EnergyAustralia

27 November 2015

**Albion Park Rail Bypass (Bypass) EIS
EnergyAustralia Comment**

# Map 3 - Southern Interchange

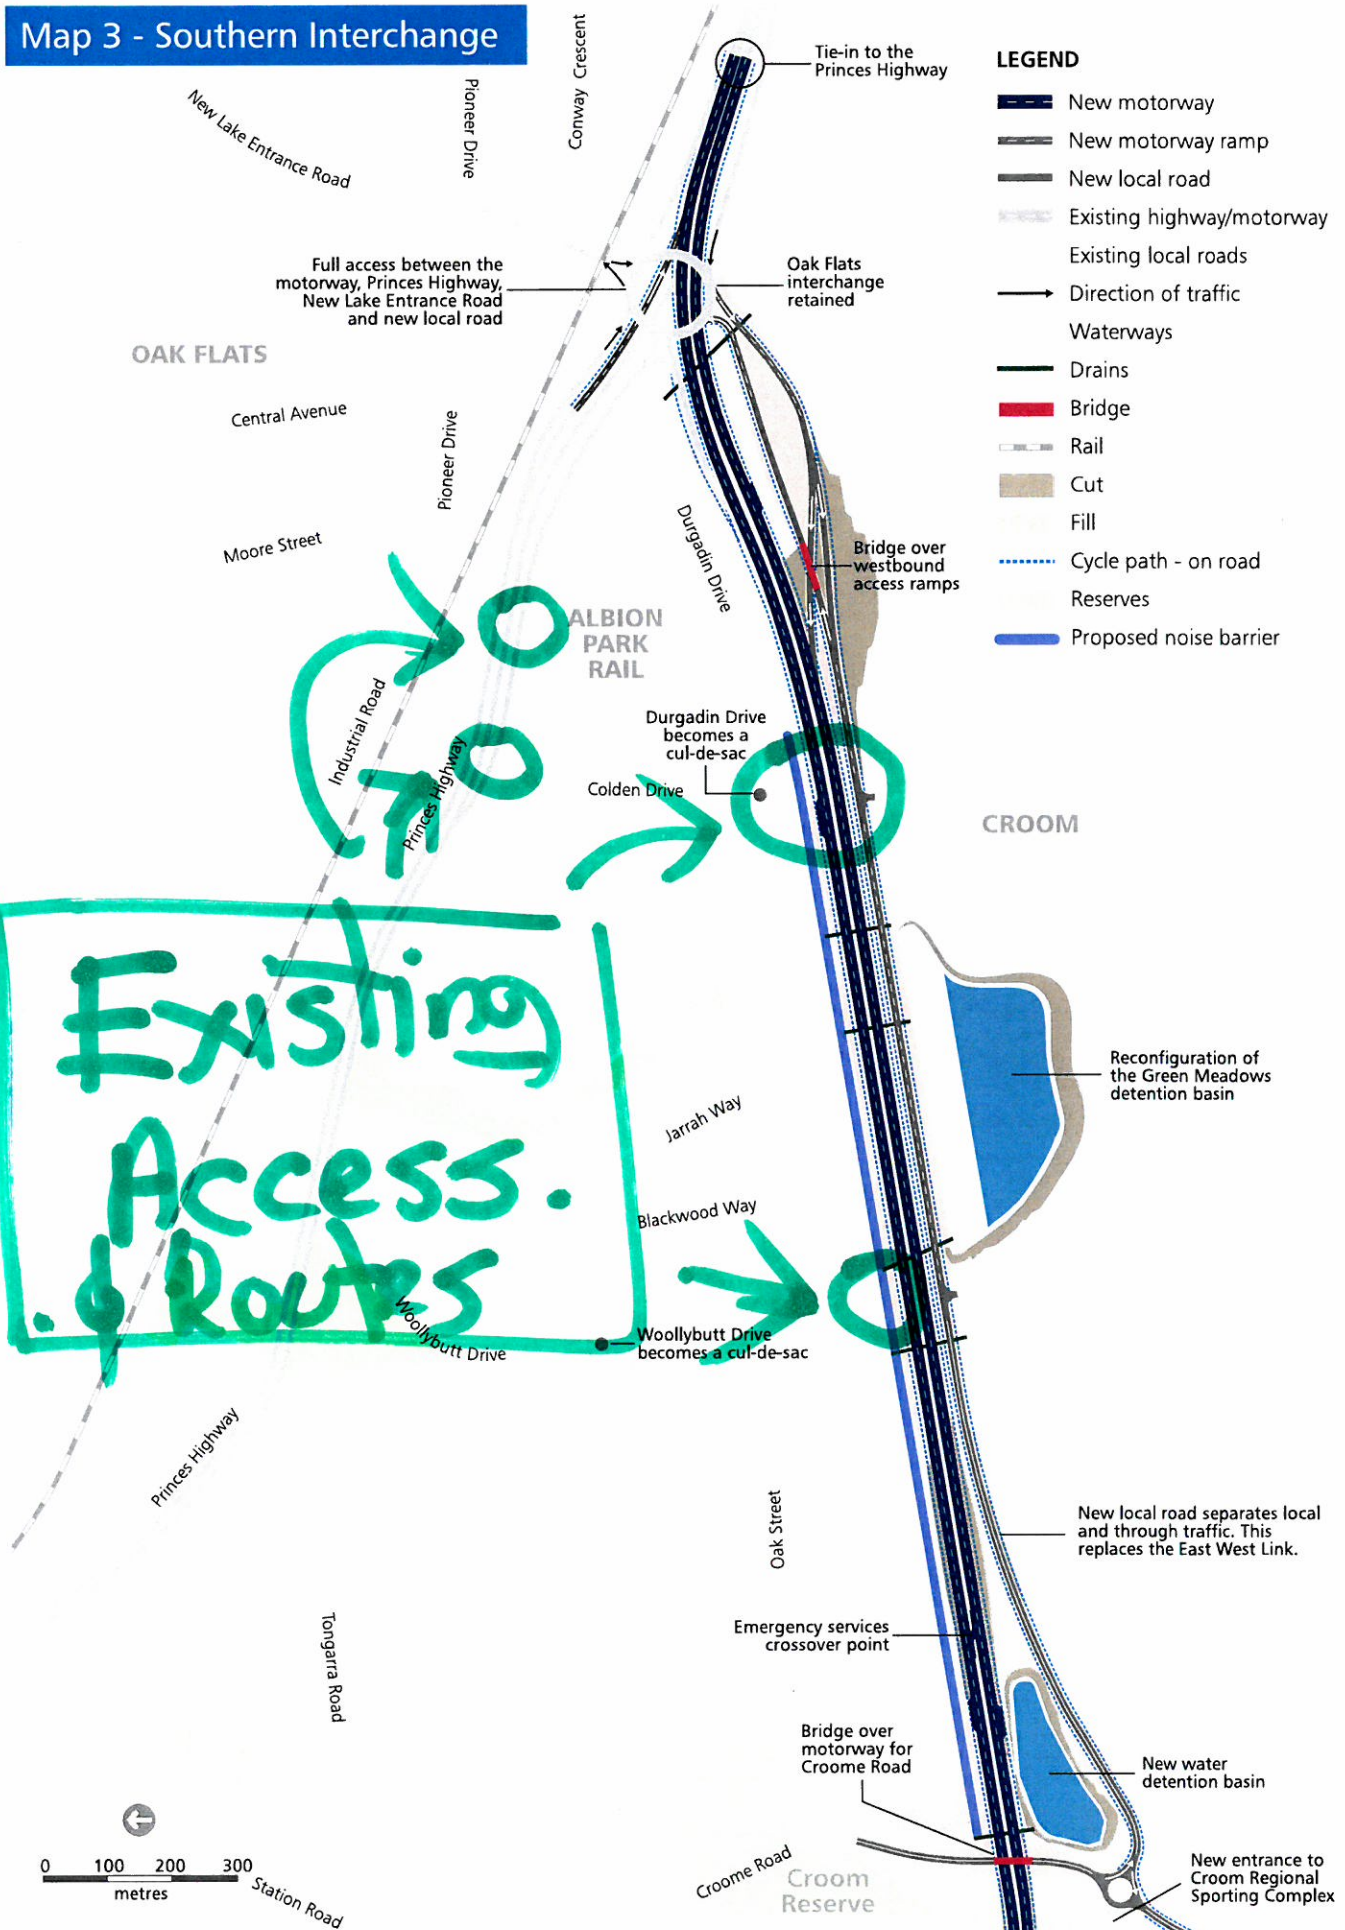
The proposed alignment of the connecting roads and ramps between Yallah Bay Road, Cormack Avenue, Princes Highway and the Bypass encroach on the Tallawarra Land and in particular the design of the Central Precinct.

- location of the roundabout and connection with Yallah Bay Road differs from proposals included as part of the Concept Plan.
- redirection of Cormack Avenue has not been included
- access to Yallah Bay Road requires additional acquisition of Tallawarra land
- lease for construction purposes of a portion of the Central precinct will potentially cause an unnecessary interruption to the land development.

Consideration of the location and design of local road alignments and freeway connecting infrastructure to avoid impacts on the Tallawarra development is requested.

The proposed alignment of the Bypass would appear to increase the noise to the sensitive receptors in the proposed Central and Southern Precincts. This is potentially being exacerbated by the location of roundabouts and access roads closer to the extremities of the Central Precinct.

Consideration of noise treatment to those sections of the Bypass and associated access infrastructure potentially impacting the Tallawarra Lands is requested.
